**PNM Comments
Development Review Board
Public Hearing to be Held on December 18, 2019**

**PNM comments for Approval for DRB #PR-2019-002184 (1001993) SI-2019-00379
Site Plan (3-story indoor Guardian Storage facility located at 4909 Juan Tabo Blvd
NE between Osuna NE and Montgomery Blvd NE)**

LANDSCAPE PLAN

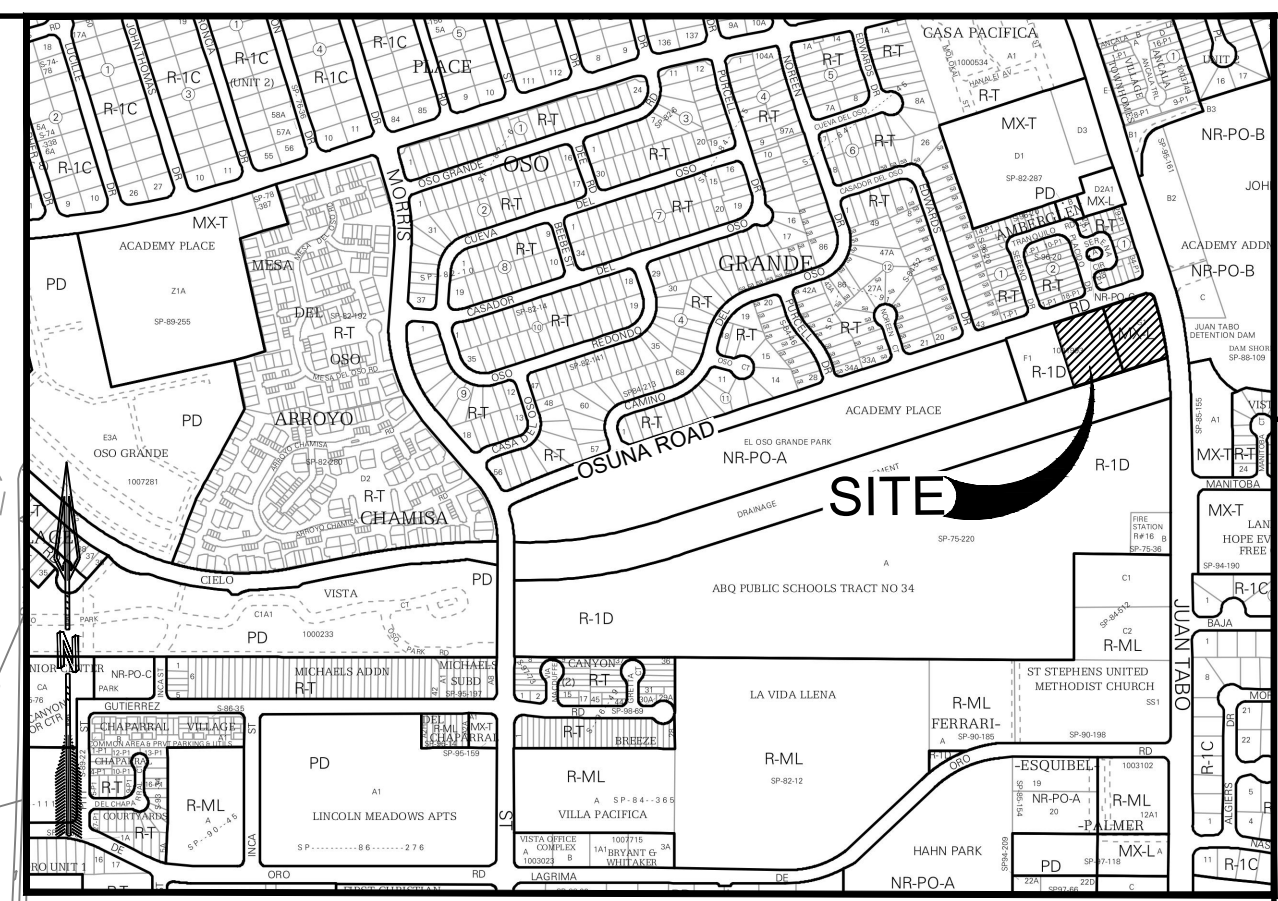
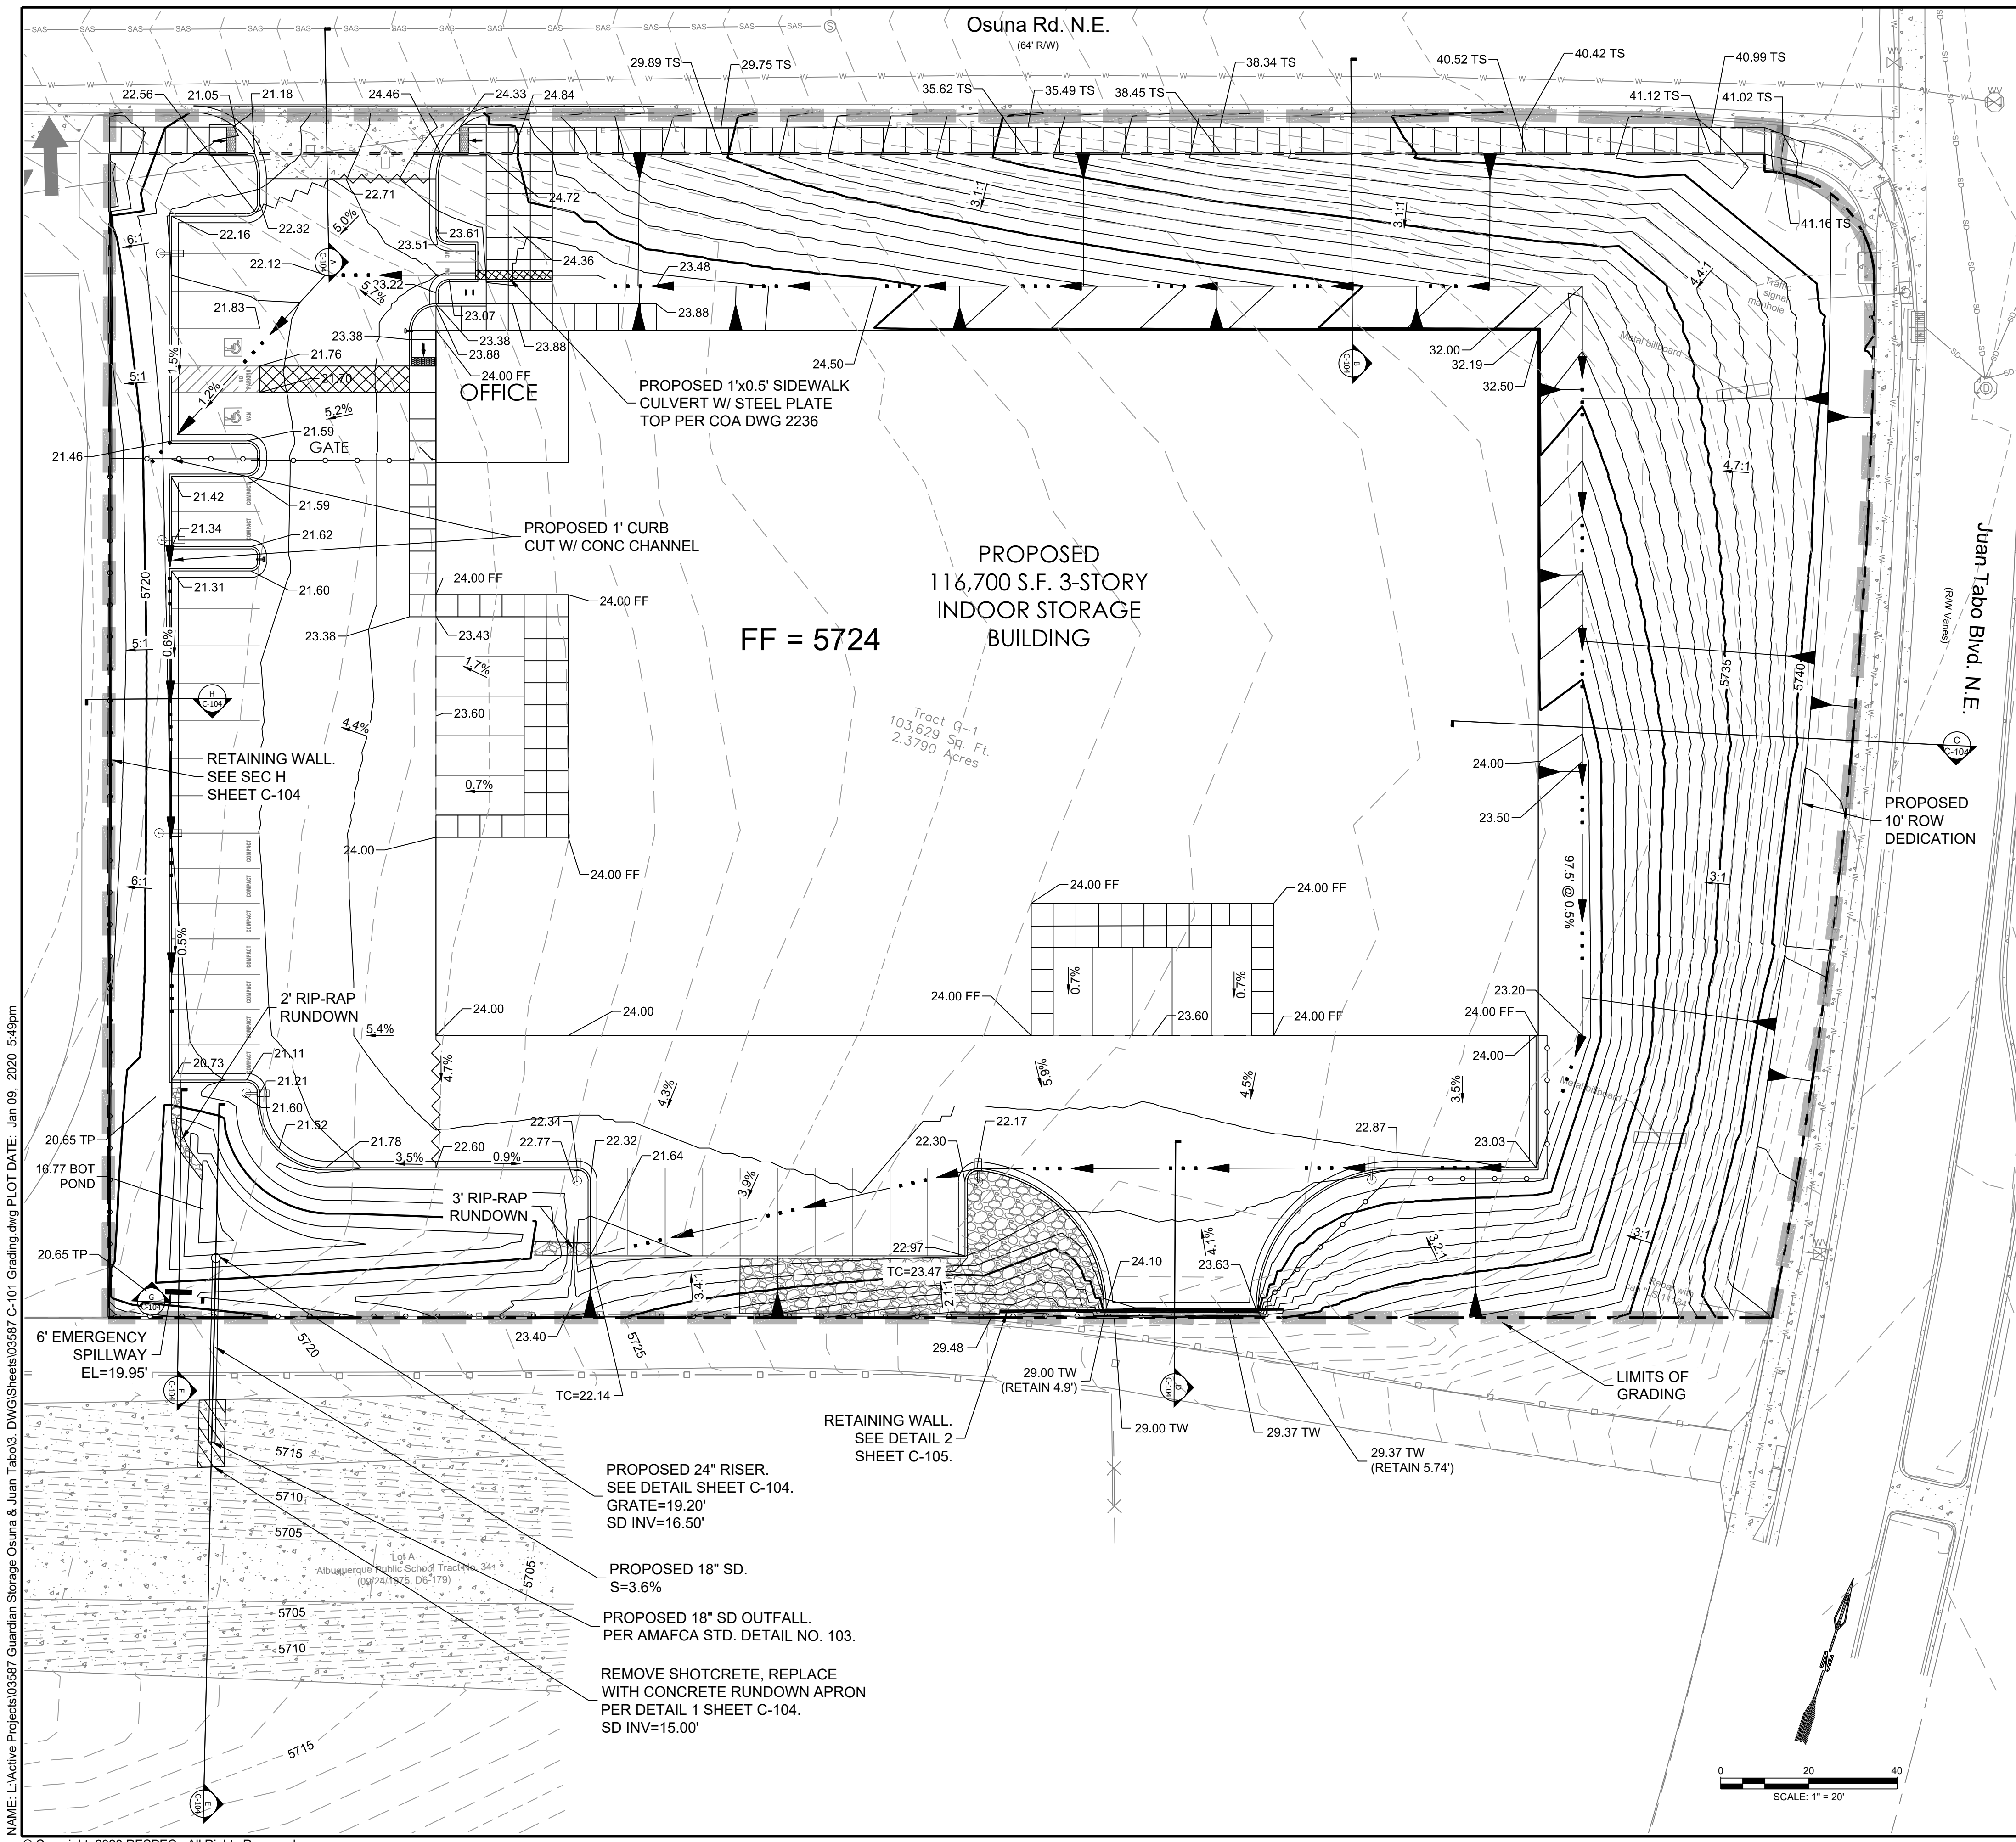
2. The proposed landscaping including one street tree as noted on the Landscape Plan (Sheet 2 of 7) at the northwest corner of the site appears to be located within the PNM underground distribution easement. PNM standard is for trees to be planted outside the PNM easement. It will be necessary for the applicant to coordinate with PNM regarding proposed tree species and placement as well as sign location in order to ensure sufficient safety clearances to avoid interference with the existing electric distribution lines along the project site.
